HINCKLEY RAIL FREIGHT TERMINAL

Comments on Written Submissions

CPRE Leicestershire

Oct 2023

Appendix A Part 2 - Vehicle Tracking Sheet 1

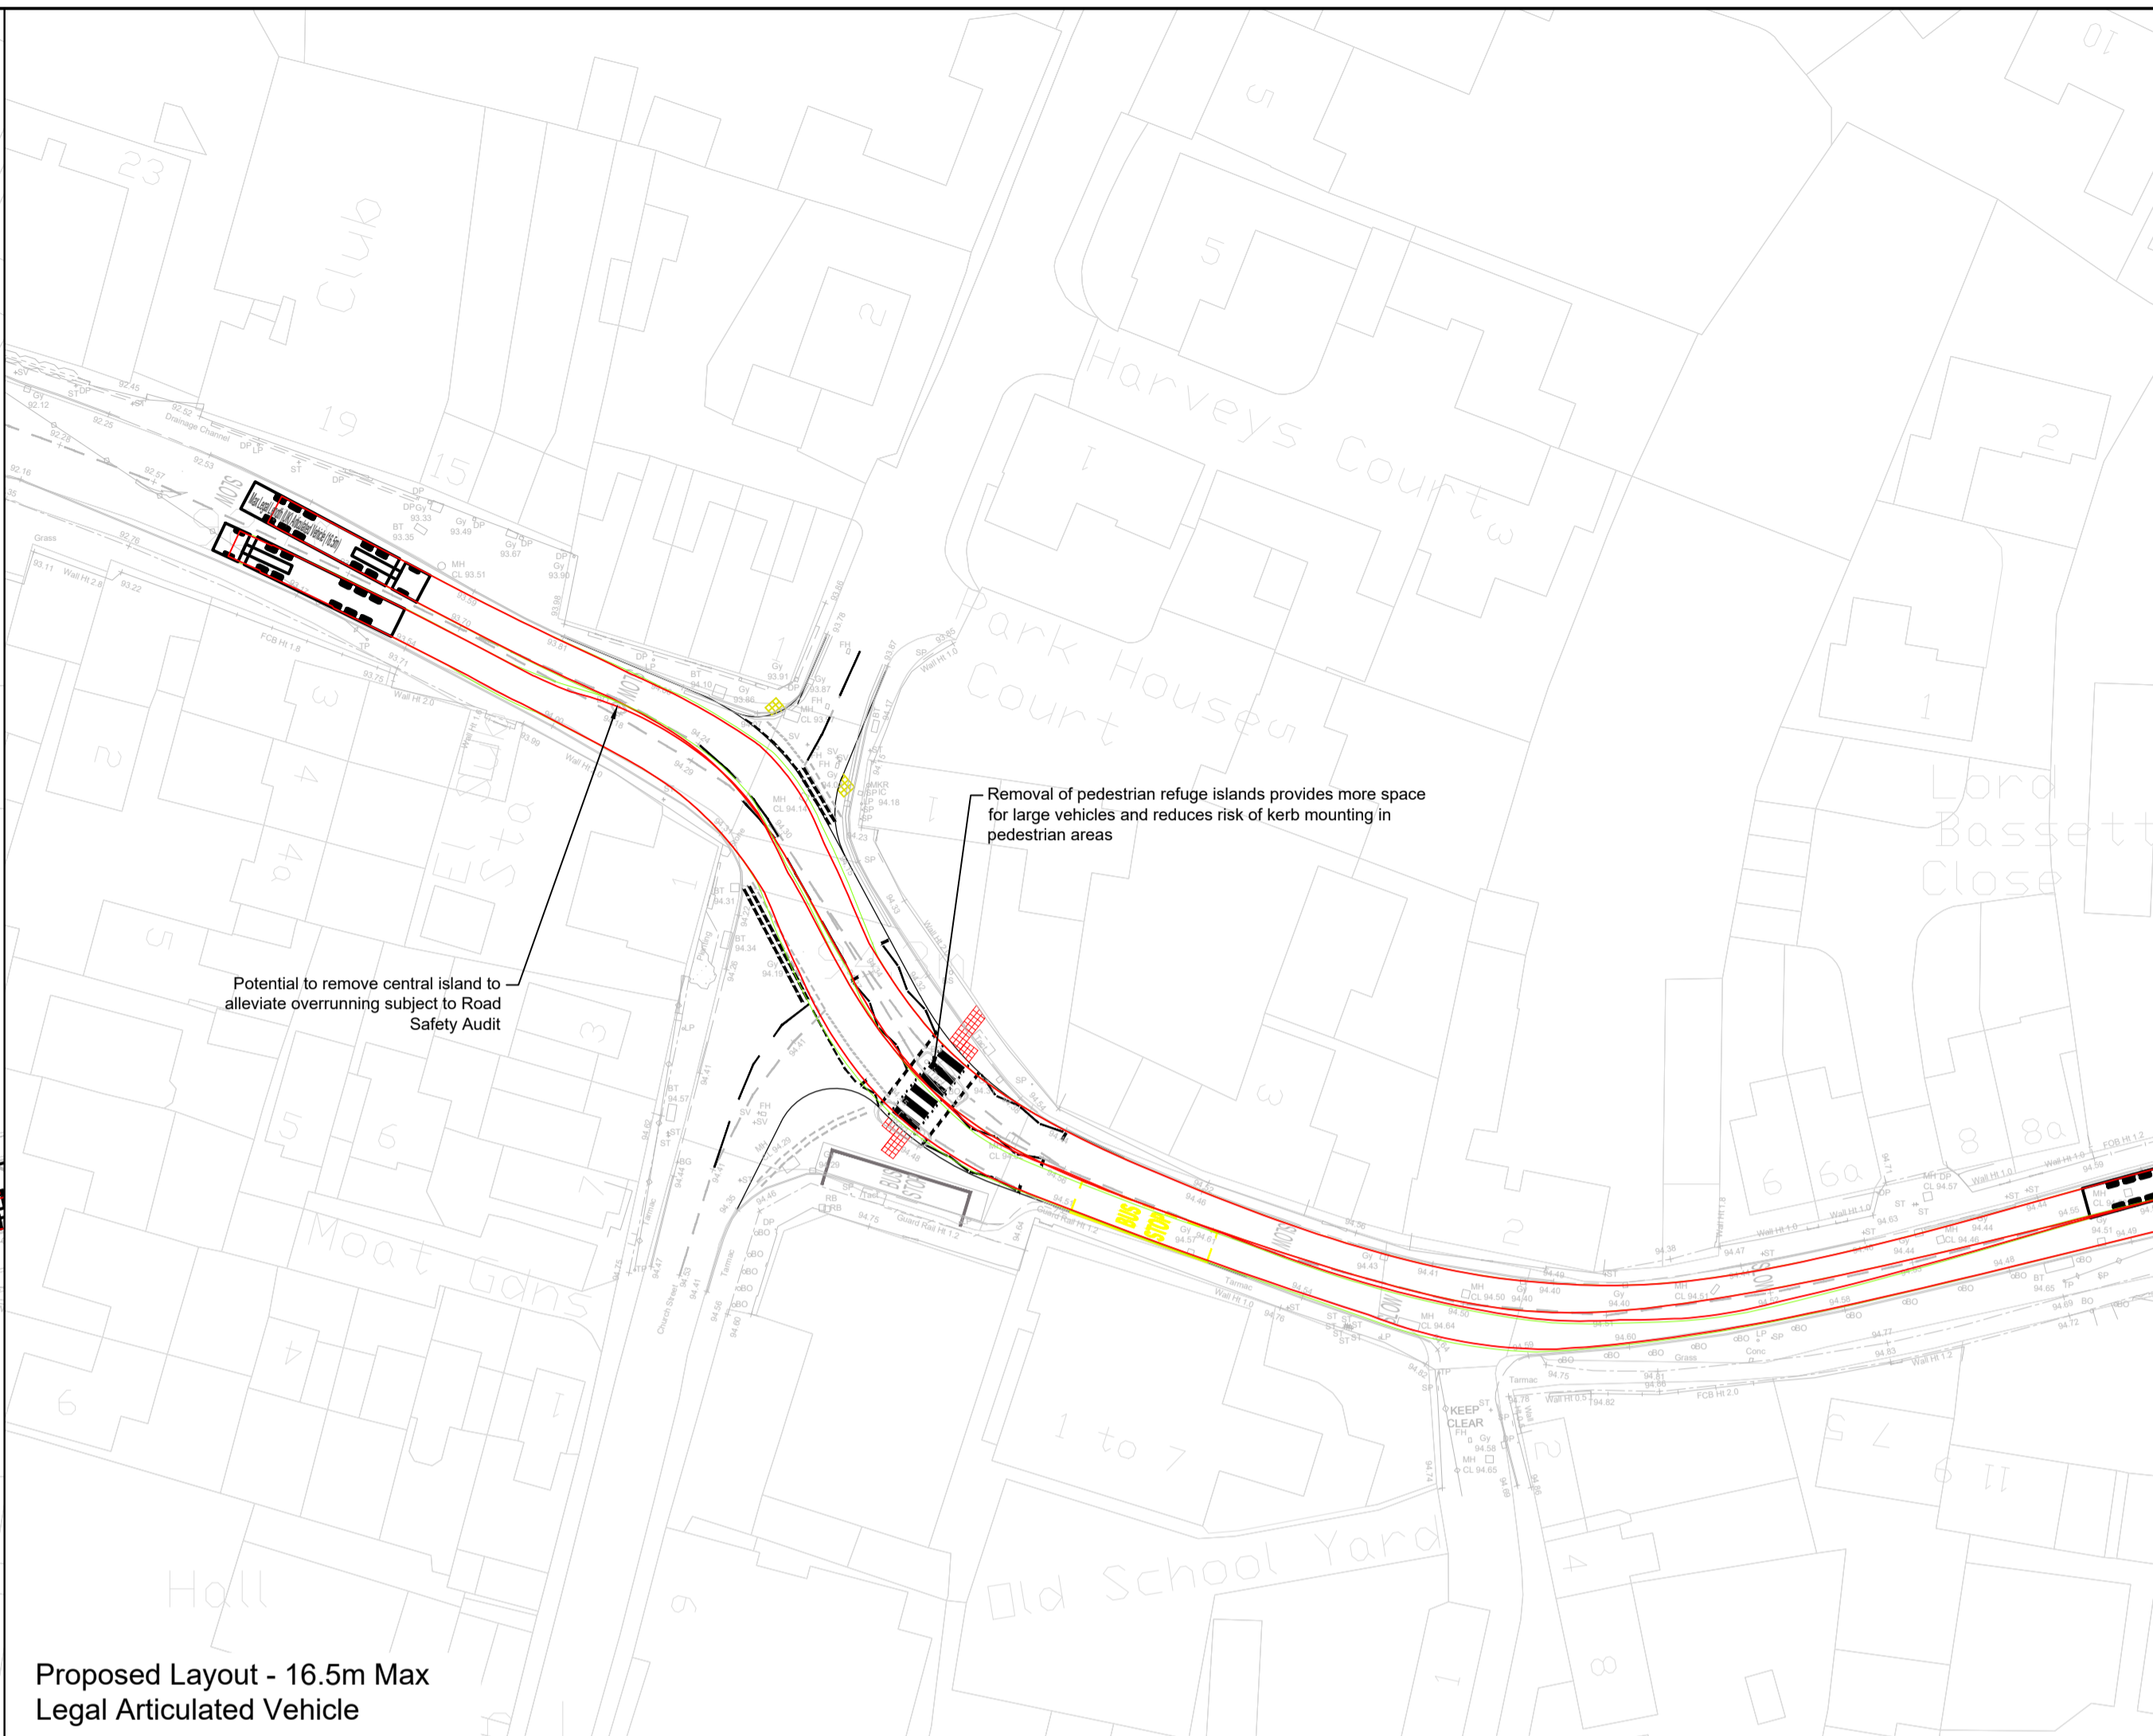
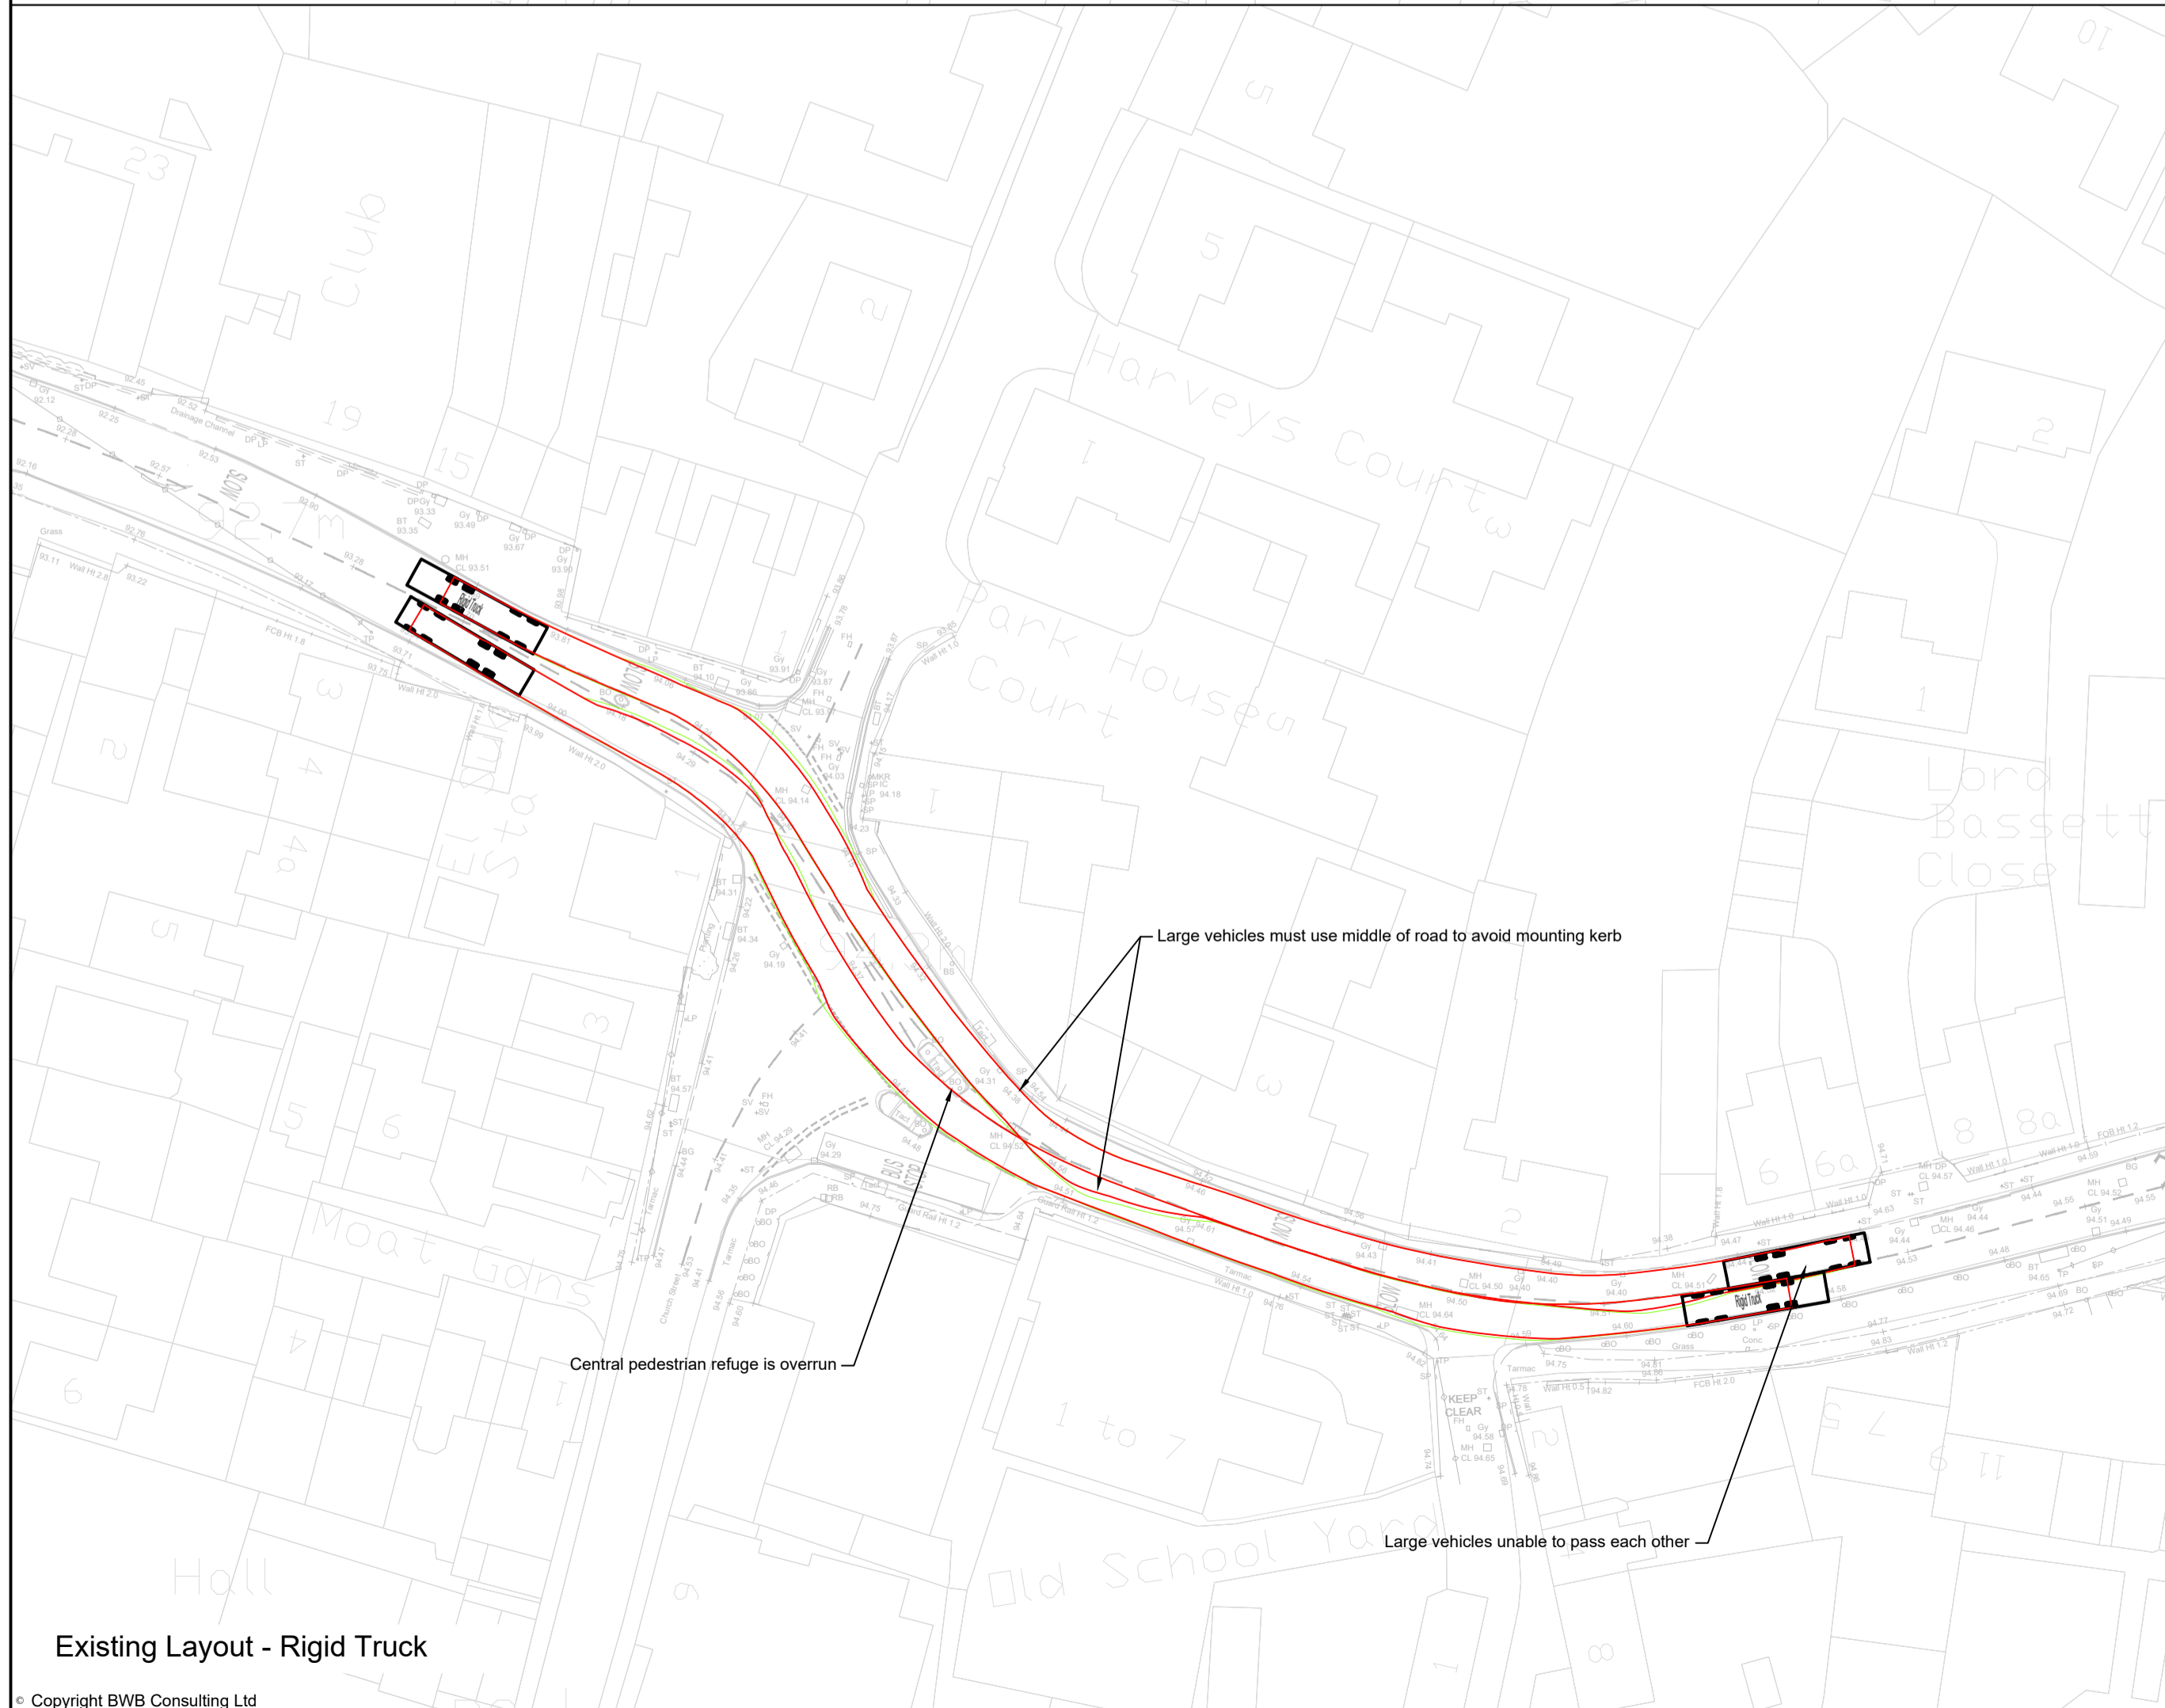
- 2.27 no vehicle tracking provided for HGVs
- 2.39 collision data from 2015-2019
- 2.44 furnishing relies on 2017-2019 counts
- 2.51 lorry park movements not included
- 2.55 Padge Hall 20% more traffic on A5
- 2.67 modelling information provided to the TWG included details not in the submission.
- 2.68 no unconstrained development modelling
- 2.72 detailed select link information on Sapcote shown to TWG but not in submission. Assessment of village not provided
- 2.89 basic design information for off-site mitigation missing from submission
- 2.100 route strategy enforcement not discussed with HA.
- 2.116 construction traffic routing limited info
